**Notice of Decision
Town and Country Planning Act 1990
Town and Country Planning (Development
Management Procedure) (England) Order 2015
Approval of Permission for Development**

Application No: 6/2019/2313/FULL

Development: Erection of six dwellings following demolition of existing buildings

At Location: 101 Brookmans Avenue, Brookmans Park, Hatfield, AL9 7QG

THIS DETAIL WILL BE APPLIED TO ALL SIX HOUSES

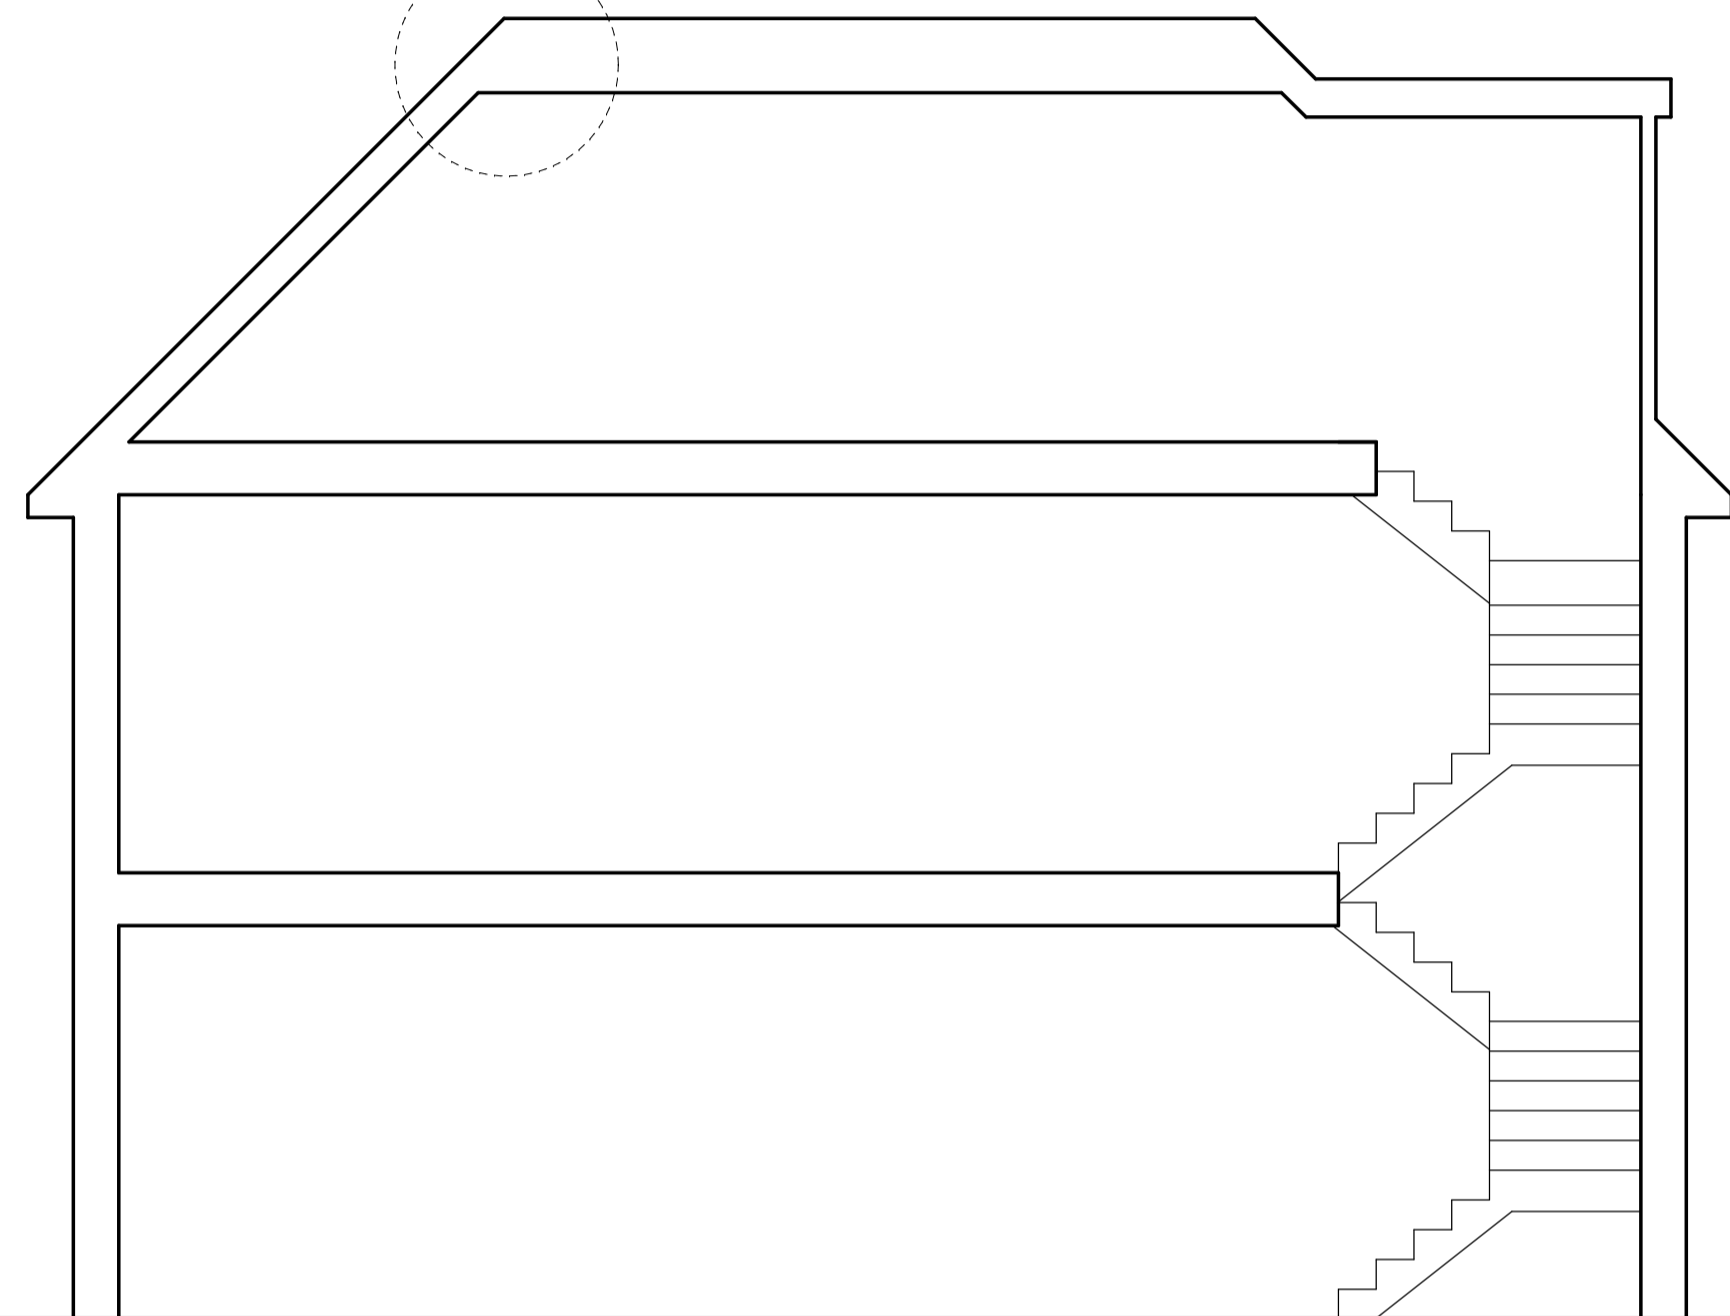
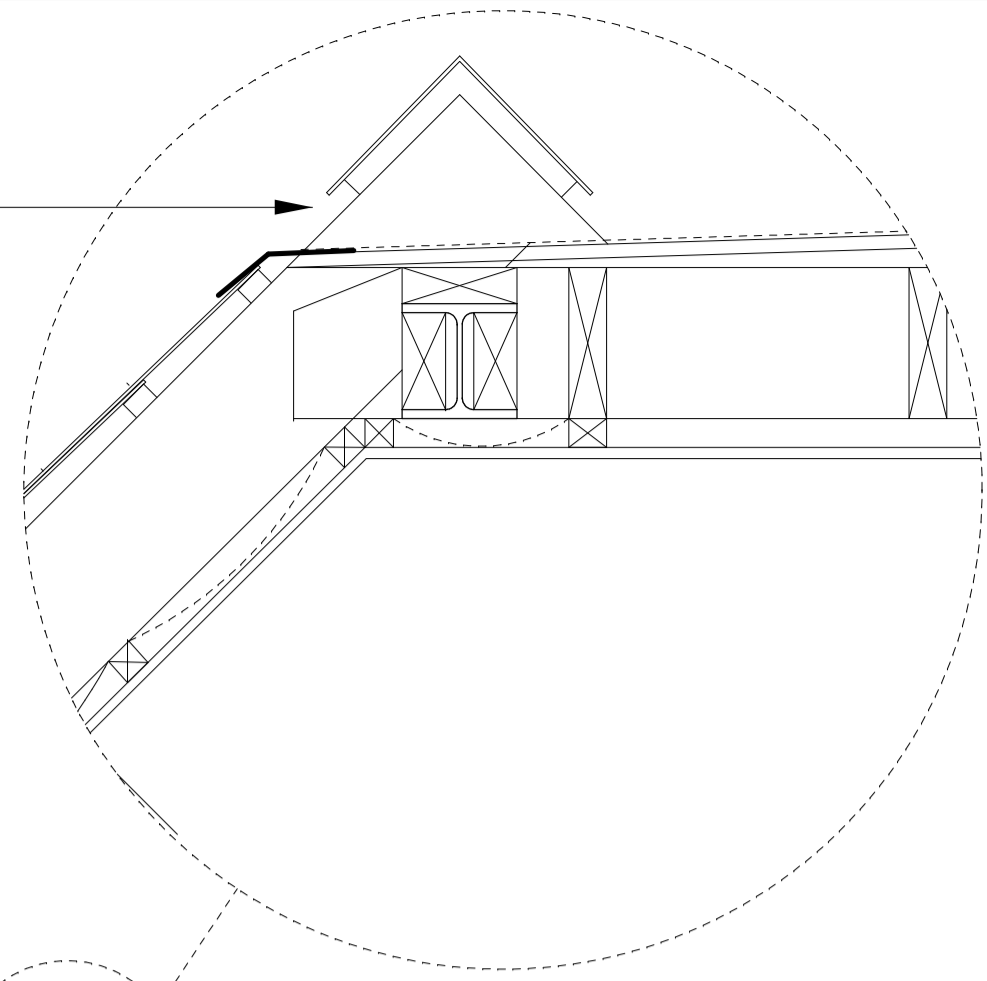
1. Notwithstanding submitted drawing number: 48 5018-26, relating to crown roof details, no development above ground level shall take place until amended details of the proposed crown roof have been submitted to and approved in writing by the Local Planning Authority. The details, including; a roof plan, elevations and sections, in either 1:50 or 1:100 scale, and applying to all dwellings, must clearly show that the flat roof is stepped down and concealed behind the surrounding pitched roof. The pitched roof must use ridge tiles. Subsequently the development must be carried out in accordance with the approved details.
